Alan Varela, Director

**Re: Old Chevron Terminal at 3200 Broadway Blvd SE
Erosion and Sediment Control Plan
Engineer's Stamp Date 5/14/24 (M14E038)**

Based on the information in your submittal received on 5/14/26, the ESC plan cannot be approved for Demolition Permit until the following comments are addressed. A separate ESC Plan and NOI must be submitted for Building Permit and Work Order.

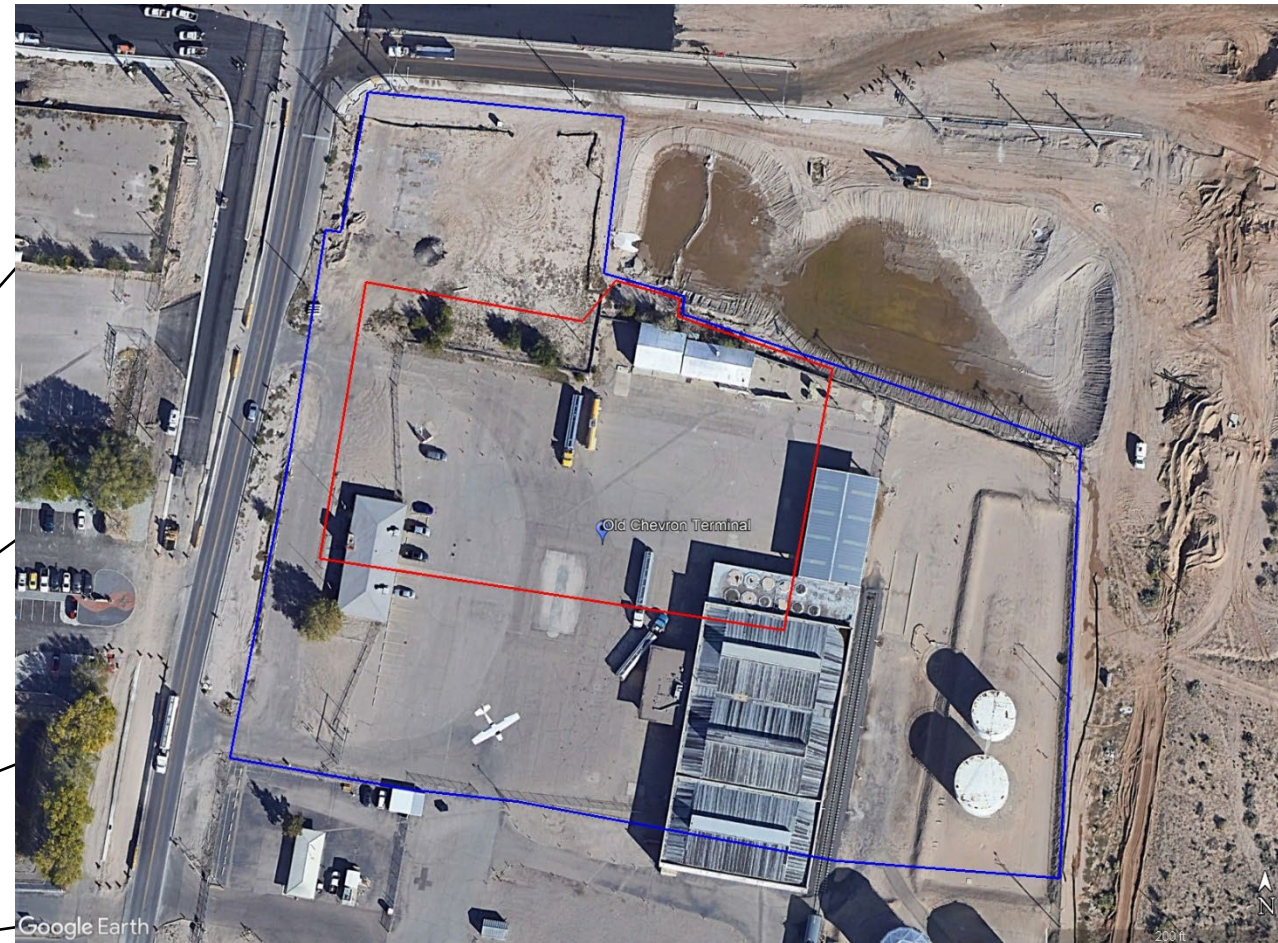
4. Comment #4 is the same as the previous letter, with additional comments. The downstream edge of this 7-acre site receives too much drainage for a silt fence alone. The Silt fence should be used in conjunction with berms and sediment basins sized to control the drainage from this 7-acre site per CGP 2.2.12. Sediment Basins must be designed and stamped by a registered Professional Engineer (PE), not a Certified Professional in Erosion and Sediment Control (CPESC). Albuquerque's Development Process Manual (DPM) Part 6-14.D.1.i requires "sediment ponds/berms for sites larger than 5 acres." CGP 2.2.12 requires temporary retention (containment) of the 2-yr 24-hr runoff volume or 3600 cf/acre from the area that drains to them, all of the areas, not just the onsite disturbed portion of the drainage area. The ESC Plan dated 5/16/24 shows a berm of unknown height around most of the outer perimeter of the site without any engineering design, calculations, or construction details, and sediment basins are still missing from the plan. In compliance with CGP 7.2.4.f, identify drainage patterns, including the location where an existing 9-acre upstream offsite area drains into the east side of this site and the two concentrated flow paths that exit this site north and south of the existing building on the west side of the site.

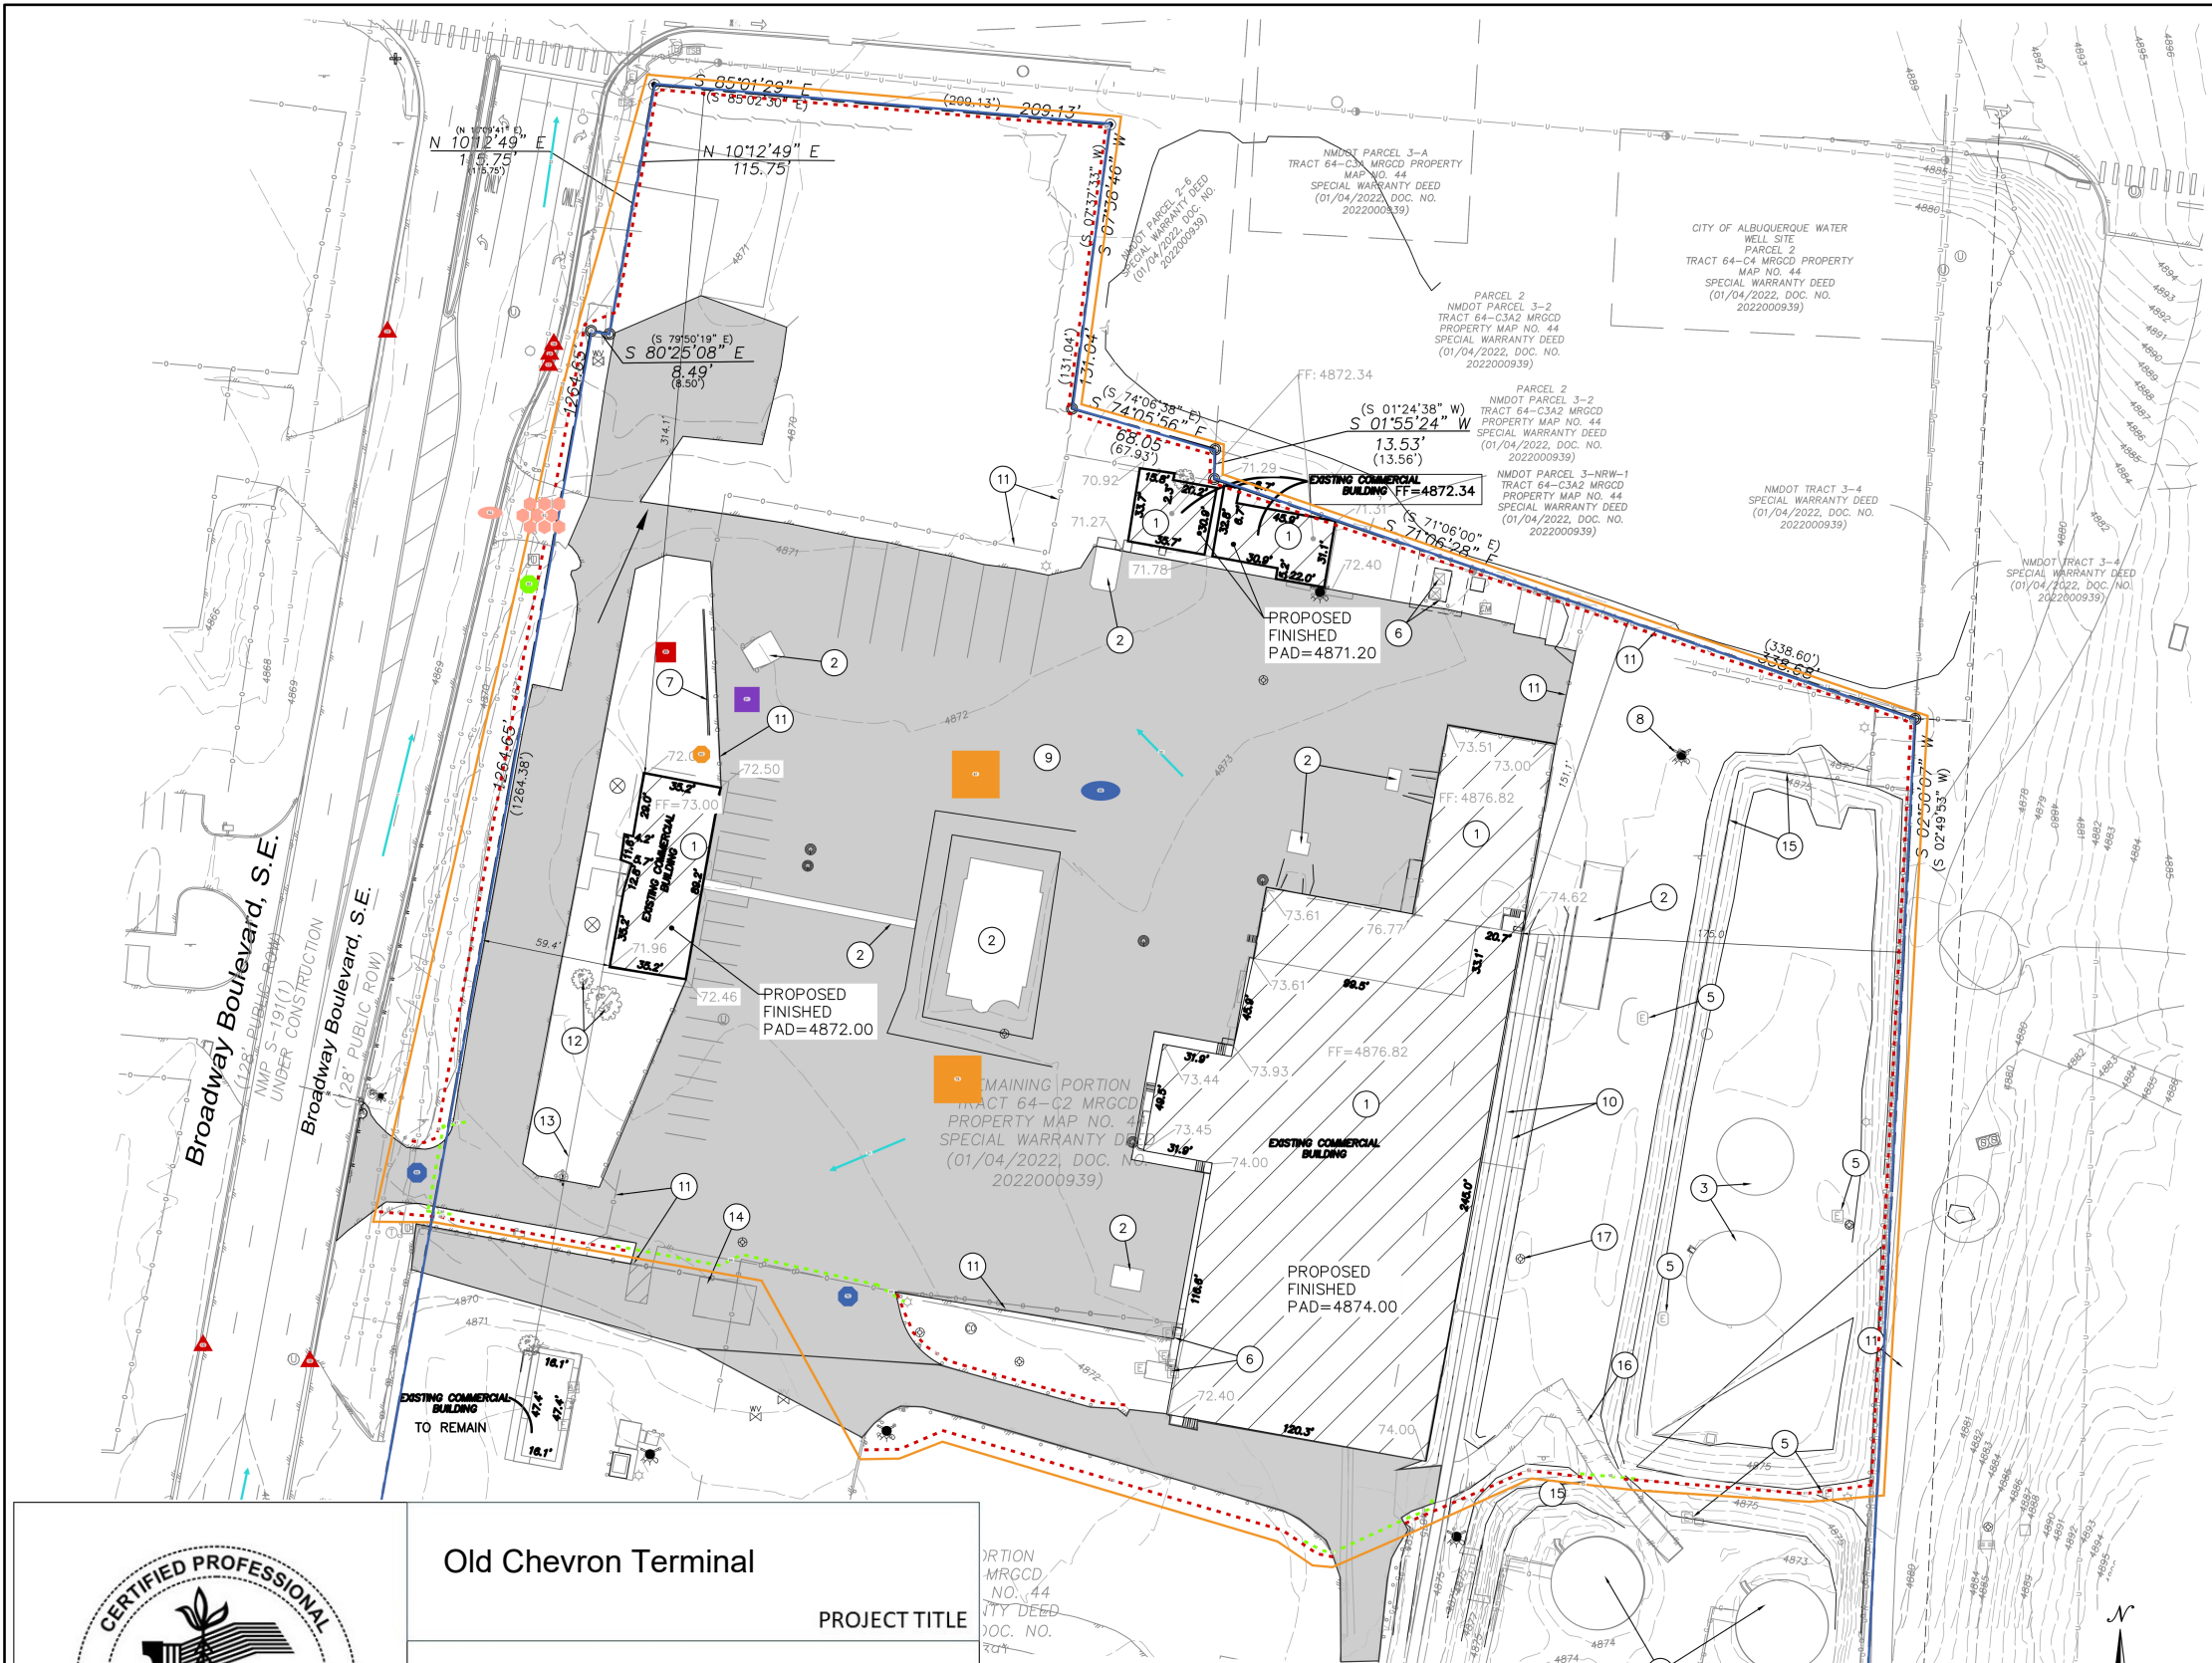
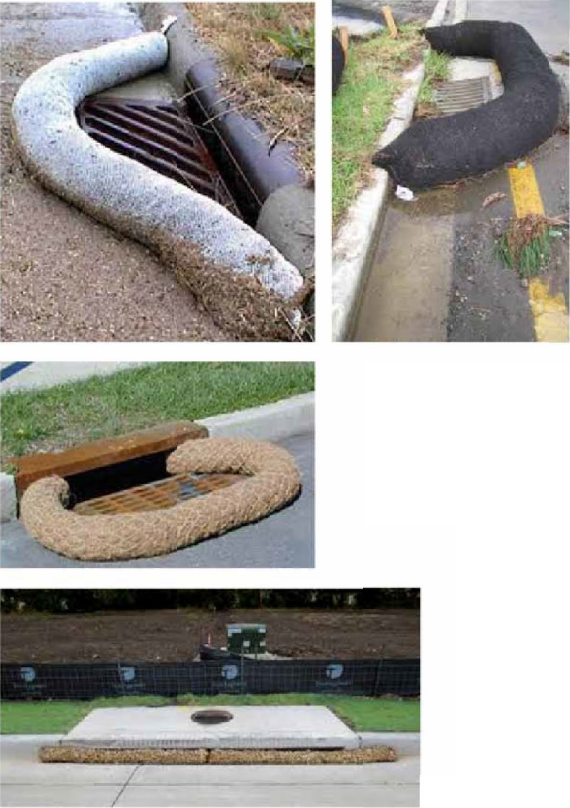
5. Comment #5 is updated to include information provided in the SWPPP. Construction, Inspection, and Maintenance standard details and specifications, as required per CGP 9.6.1.c.i., are missing from the ESC Plan. The details on sheet 3 of the ESC Plan don't include any of the required specifications. Some of the details and specifications are in the SWPPP but the city of Albuquerque requires the details and specifications in the ESC Plan. The only three pertinent details that I could find in the SWPPP are the Waste Management (WM-4), the Silt Fence (SE-1), and the Construction Exit (TC-1), but the "Compacted Earthen Berm" and the "Gator Guard – Weighted" details were not found. Additional sediment basin and/or sediment trap details and specifications are required on the esc plan along with design calculations. Both the details and the calculations must be stamped by an NMPE. All of the pertinent details must be included in the ESC Plan on 22" x 34" sheets per the city drafting standards in DPM Part 4-2(B). The SWPPP isn't required as part of the ESC Plan submittal. Instead, the city SWQ Section will check it during site inspections.
